**MIXED USE DEVELOPMENT (SSD-10378-MOD-2)- 42 HONEYSUCKLE DRIVE
NEWCASTLE**

I refer to the Department's electronic notification of 28 January 2022 advising a Section 4.5(1A) application has been received to modify the development consent (SSD-10378) for the above development and inviting City of Newcastle (CN) to provide advice. The application is seeking approval to amend the approved building design.

The Modification Report, Design Statement and modified architectural plans have been reviewed and the following advice is provided for the Department's consideration:

Check all dimensions and site conditions prior to commencement of any work, the purchase or ordering of any materials, fittings, plant, services or equipment and the preparation of shop drawings and or the fabrication of any components.

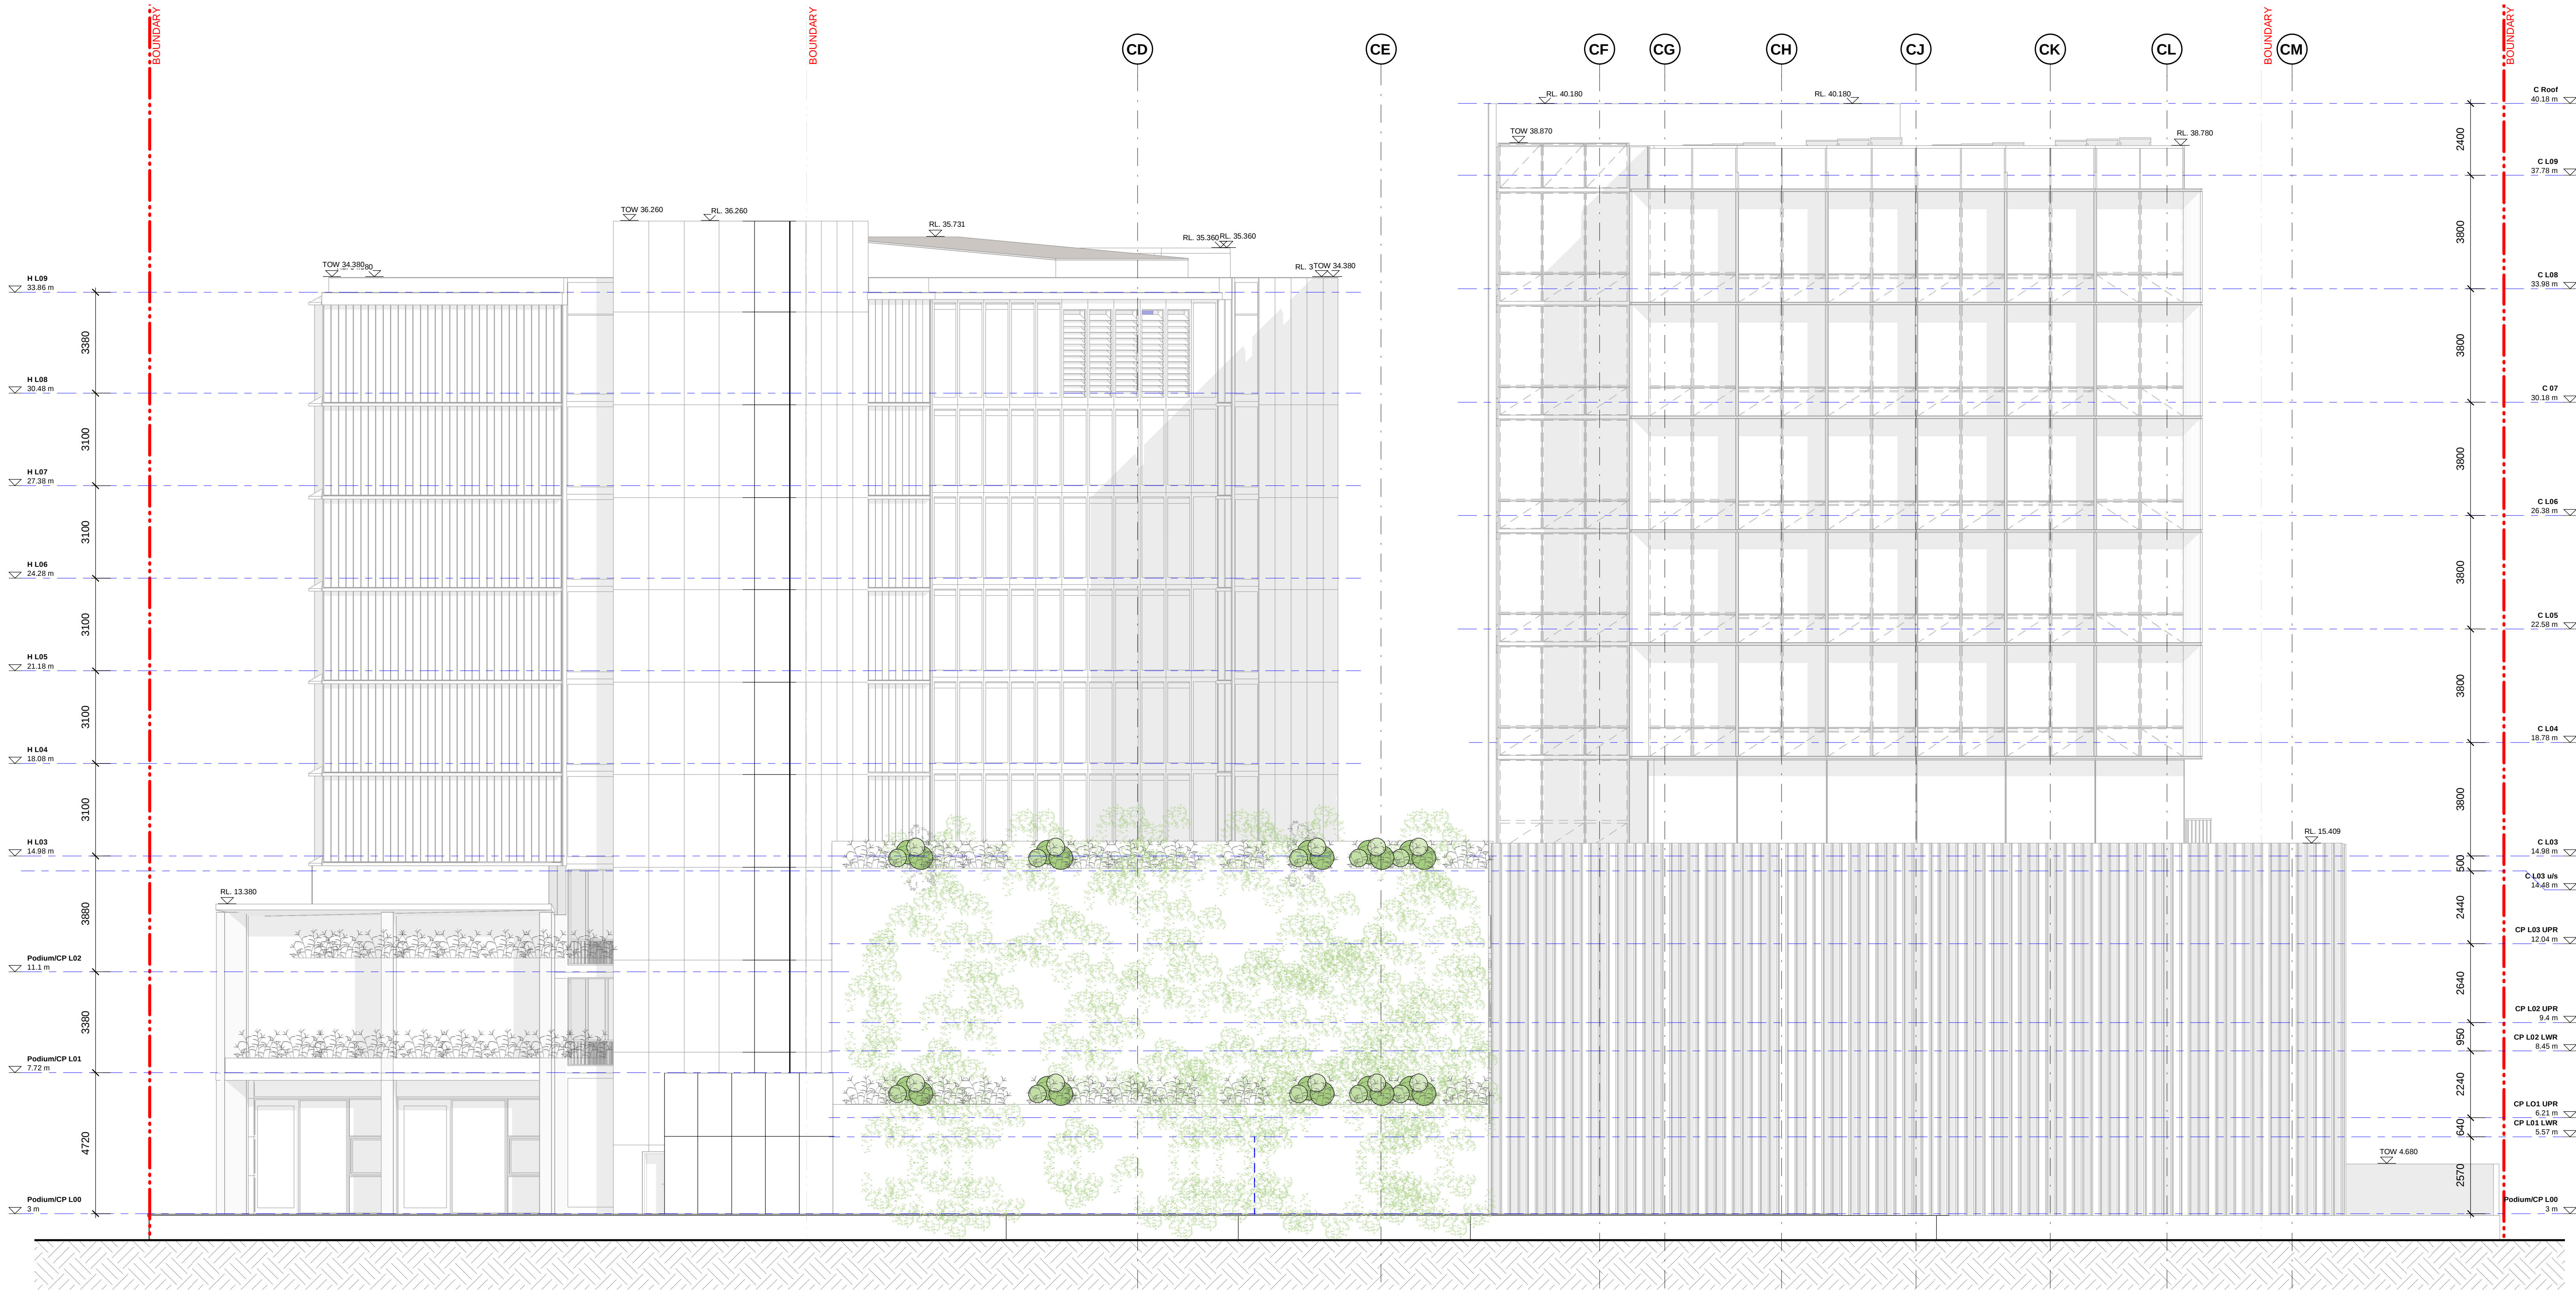
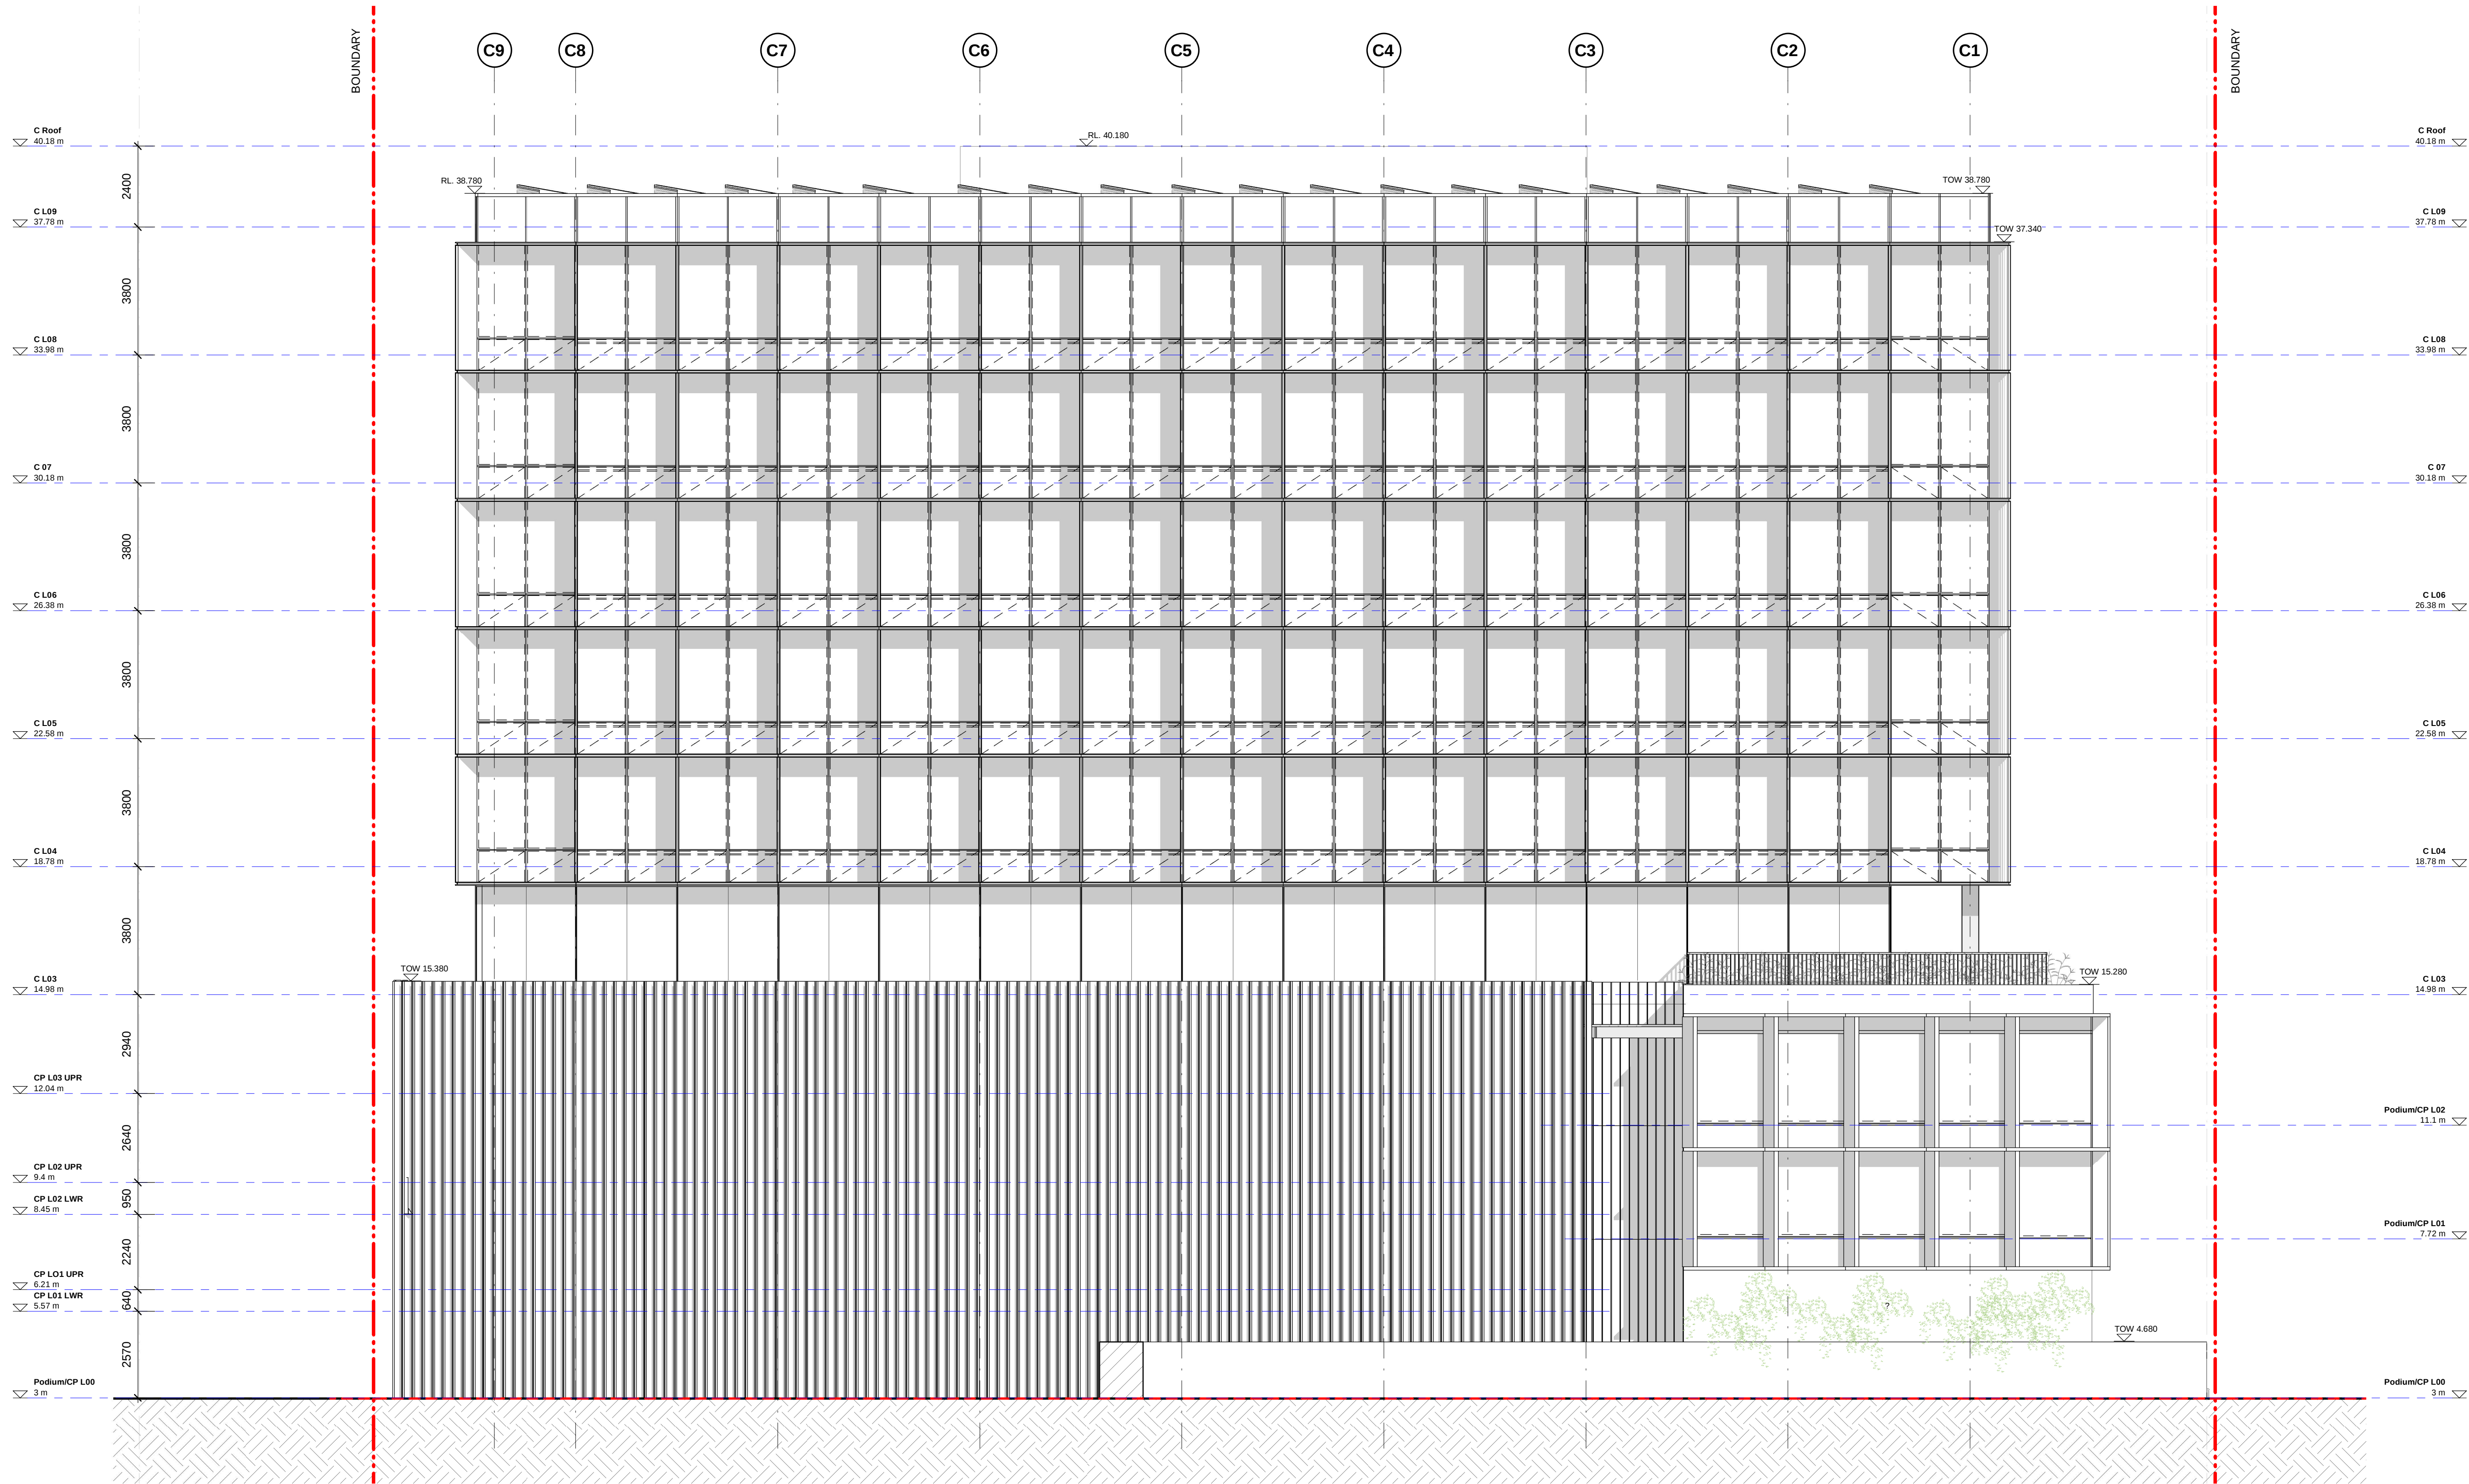
Concern is raised at the level of detail provided on the modified elevational plans compared to the approved plans. It is recommended the applicant is required to provide modified elevational drawings which show the same view and level of detail of the proposed modified development as provided for the approved development, including external colours, index of external building materials, and the approved building heights and proposed variations.

Furthermore, there appears to be changes proposed to the external appearance of the hotel and commercial building which are not acknowledged on the modified elevational plans.

1.1 DESIGN CHANGES FIRST FLOOR

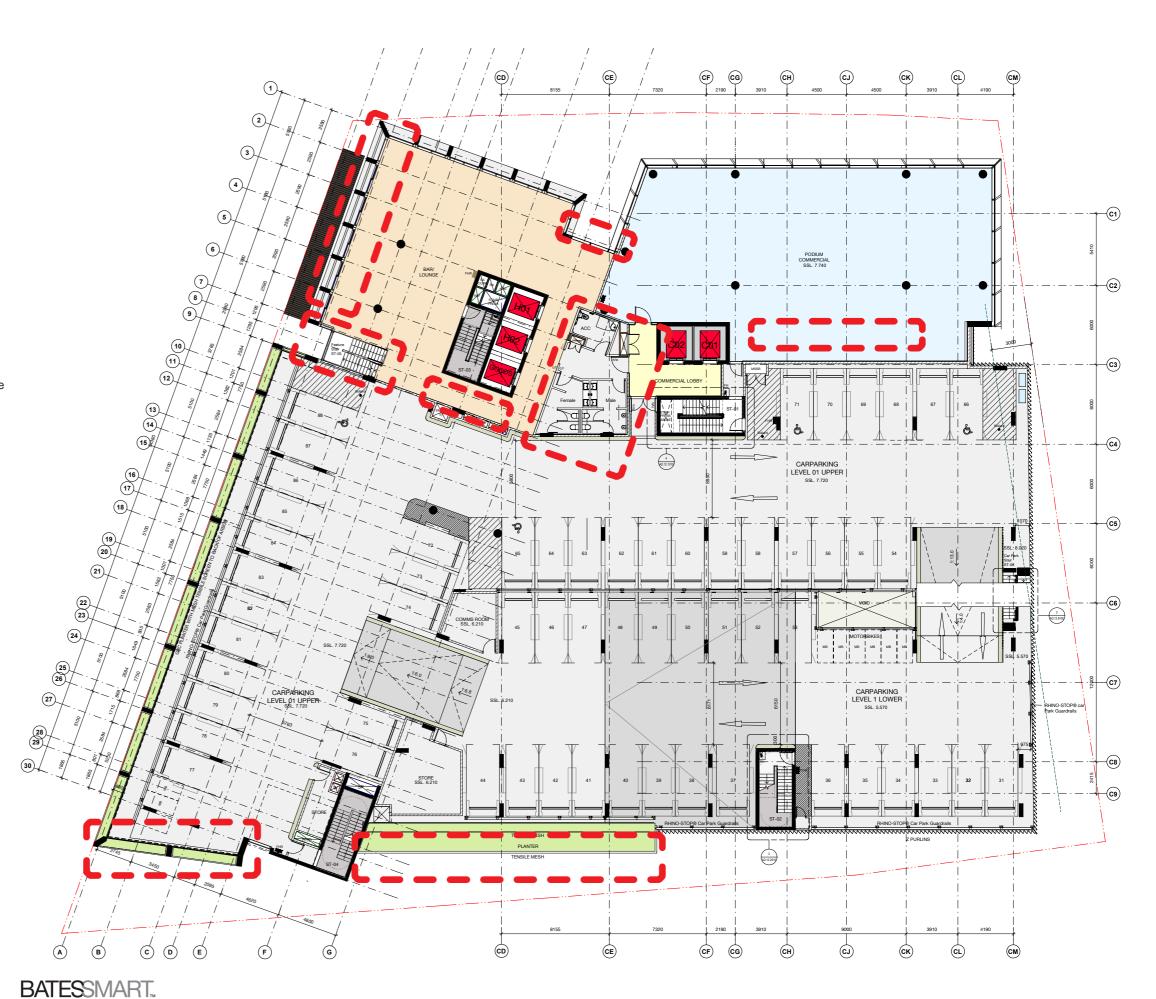
Item 6 of the 'Proposed DA Amendments' indicated on first floor plan in the Design Statement incorrectly refers to the loss of one parking space due to the proposed reduction in the length of the western elevation. It should state two spaces.

It is noted that two parking spaces for persons with a disability are being removed from the first and second floor car parking. It is recommended that the applicant is required to confirm that the remaining number of disabled parking spaces meets the relevant legislative requirements.

2.1 DESIGN CHANGES SECOND FLOOR

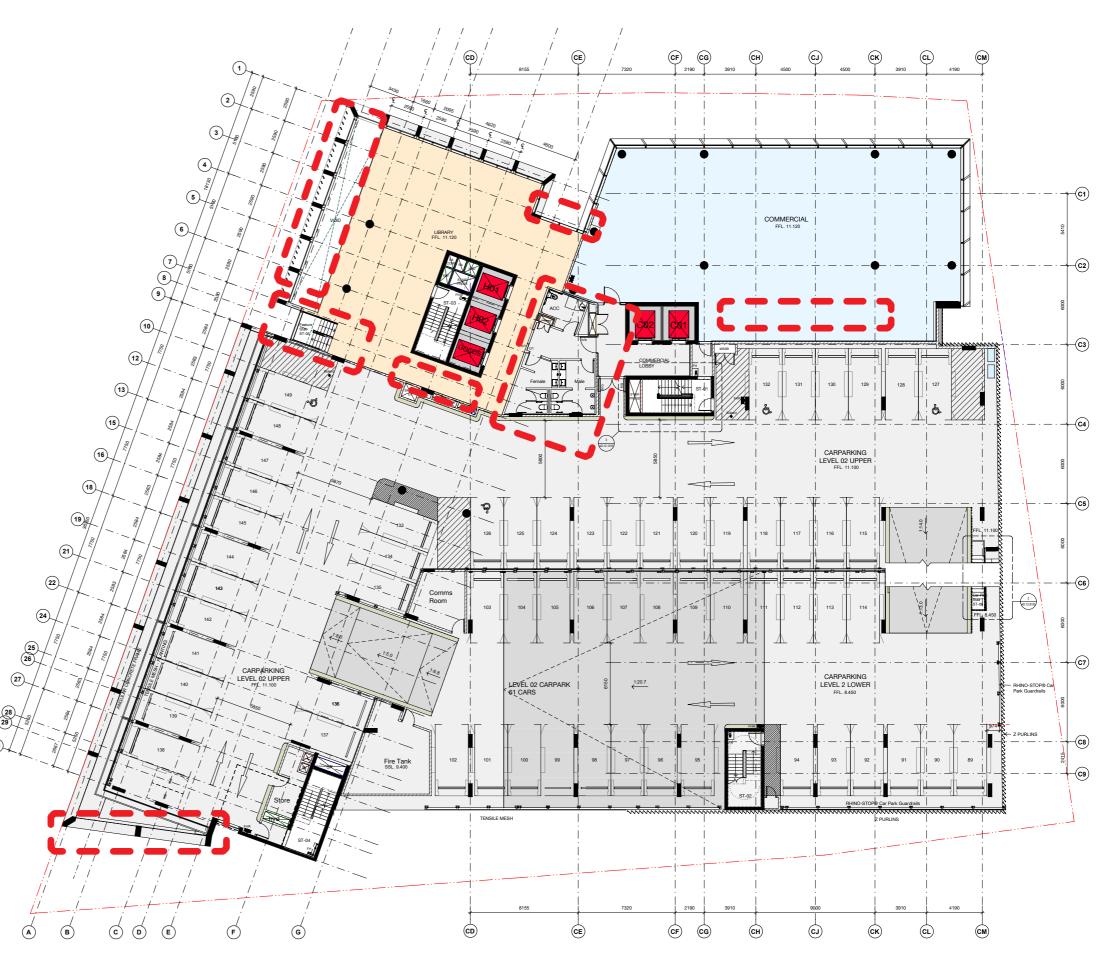
It is noted design changes are proposed to the 'Hotel lounge/library' on the second floor of the hotel. It is recommended that clarification is sought from the applicant of the proposed use of the 'library'.
